Your Ref: OWPC26544
Our Ref: R/66/20/PL 23-03-2020
Please ask for:
Amy Myer

Residential development consisting of 1 no new dwelling.

Land adjacent to 19 The Bramblings Rustington

DRAWING TITLE			
Site Plan, Street Elevation Block Plan and Location Plan

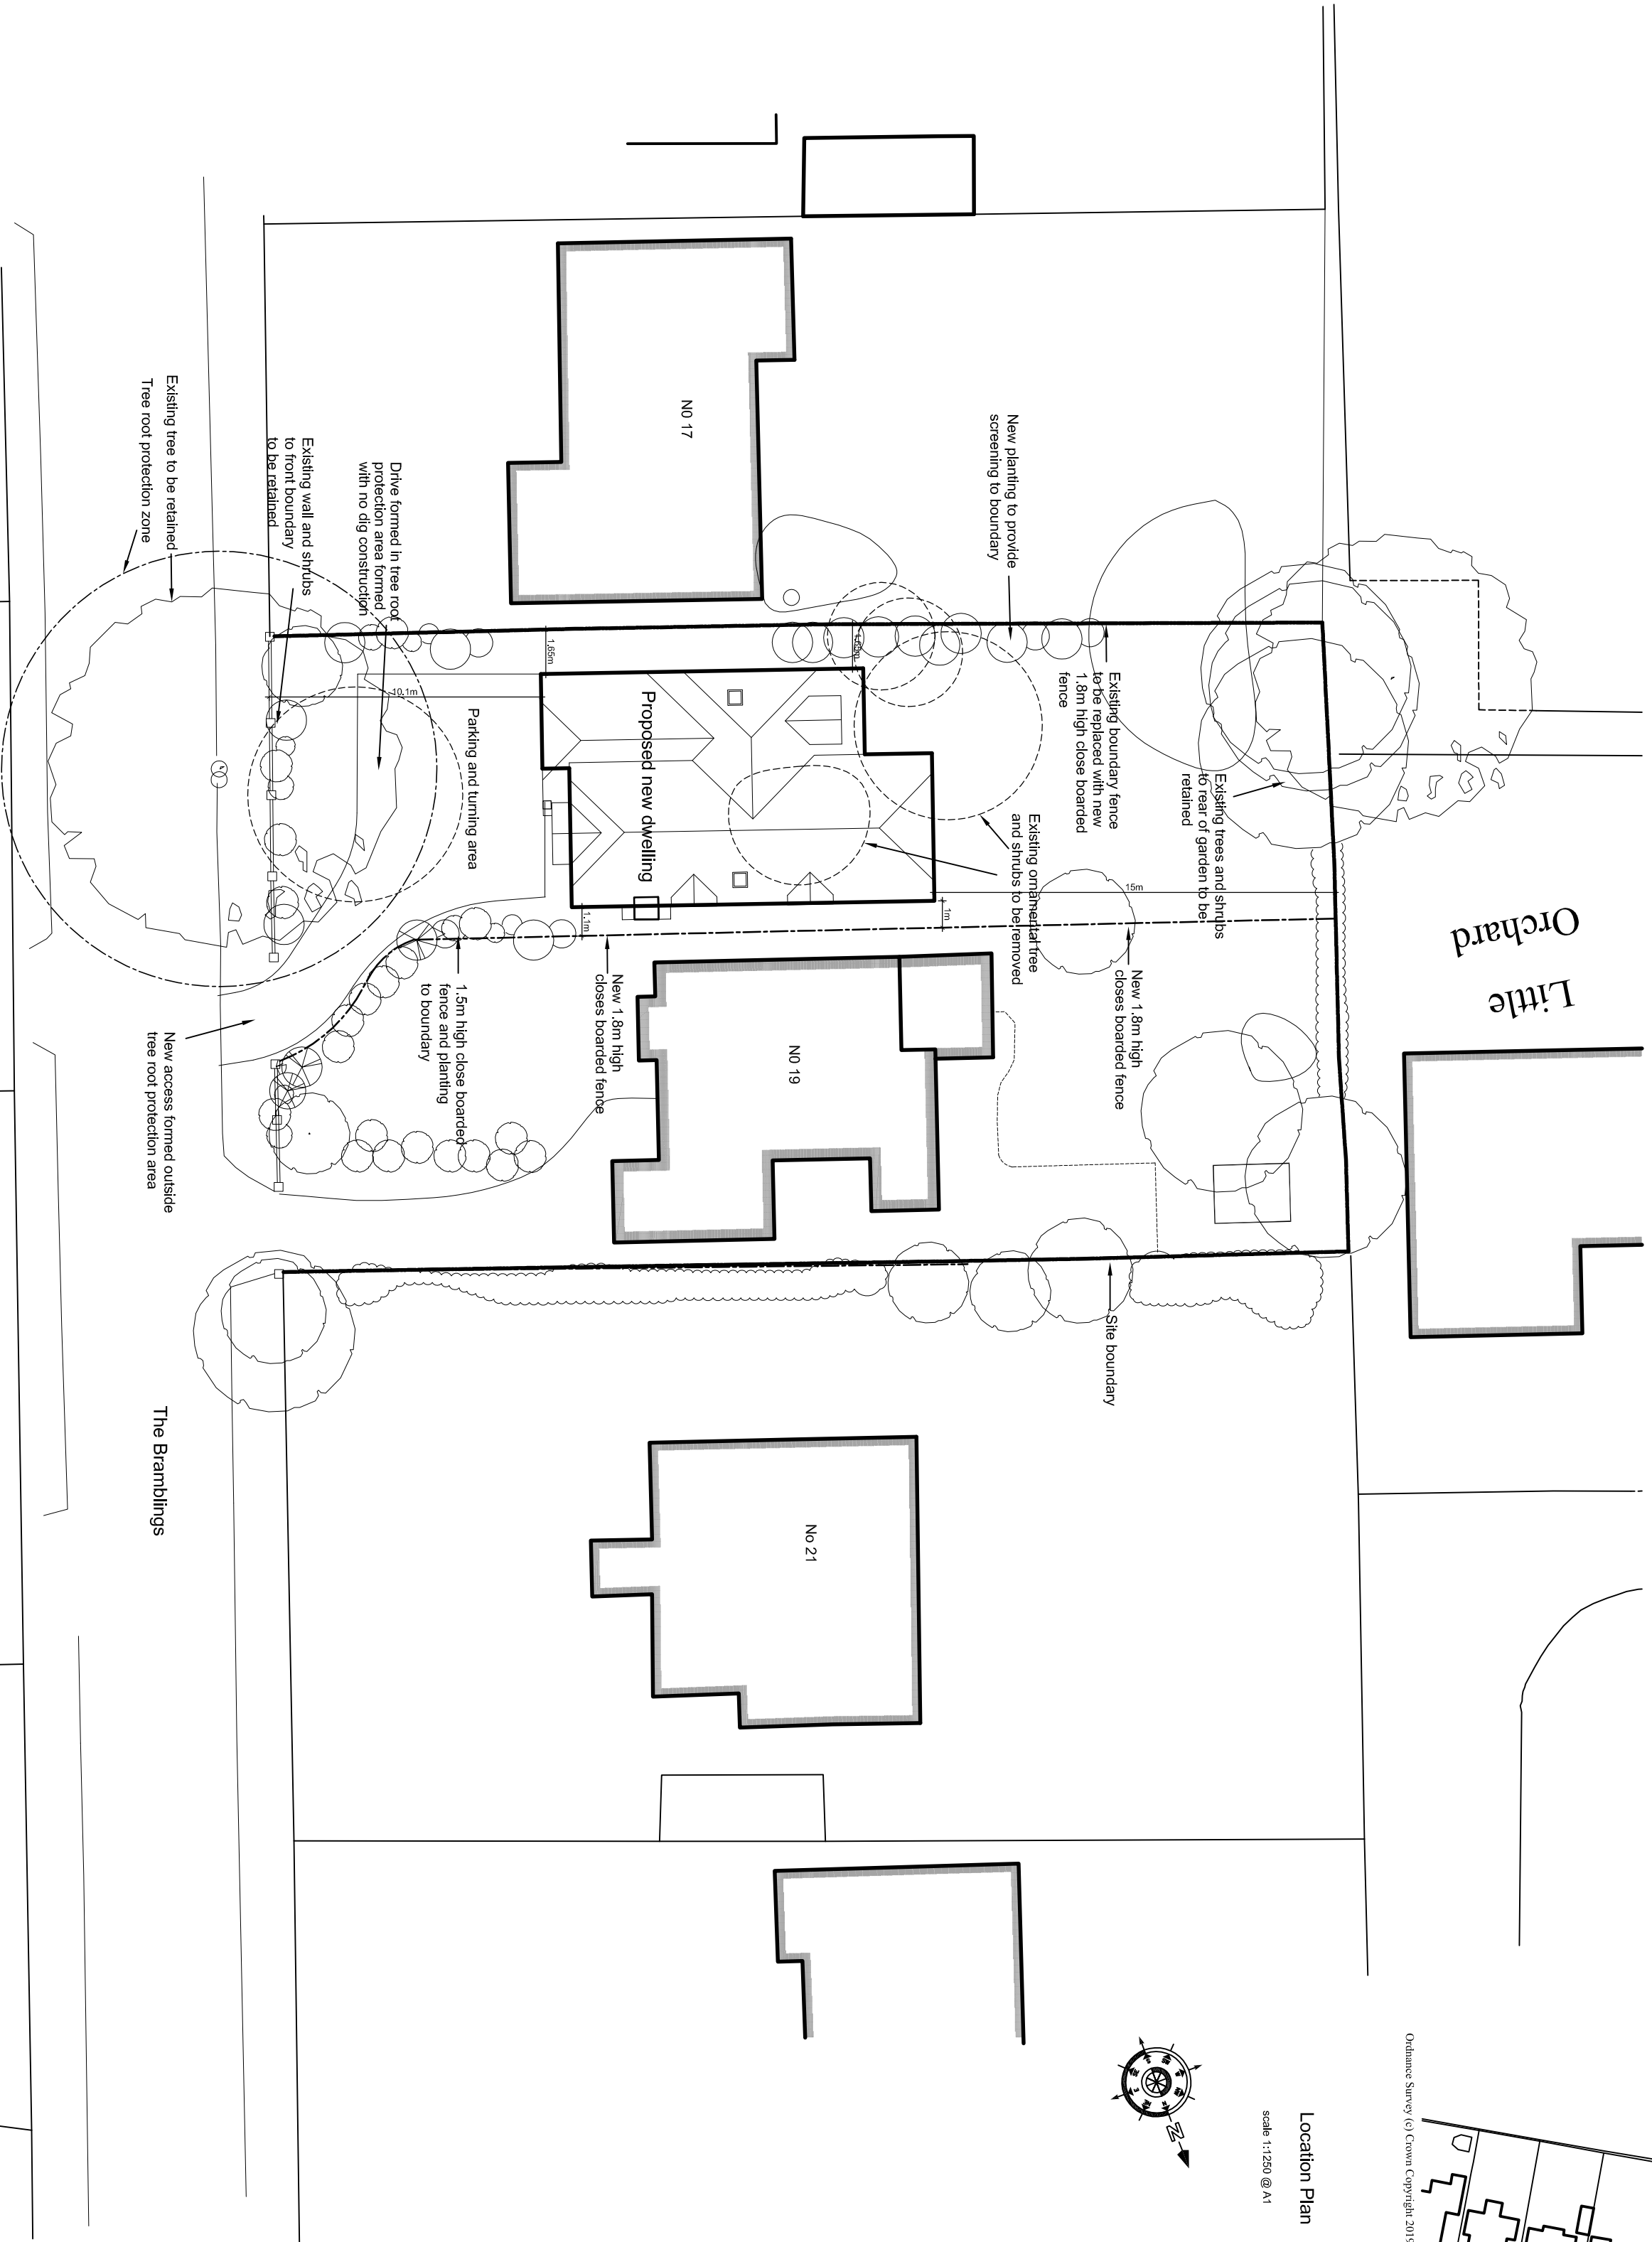
The size and nature of the plot are barely sufficient to support a supplementary dwelling and would create three access points on the west side of The Bramblings, all within 25m, and with limited sightlines.

Section 3.5 of the Planning/Design and Access Statement suggests that the new development will have room for three cars, with a further three cars at No.19; this is excessive and would have a negative effect on traffic flow; the Estate's management rules state that parking on the Estate's roads should be avoided.
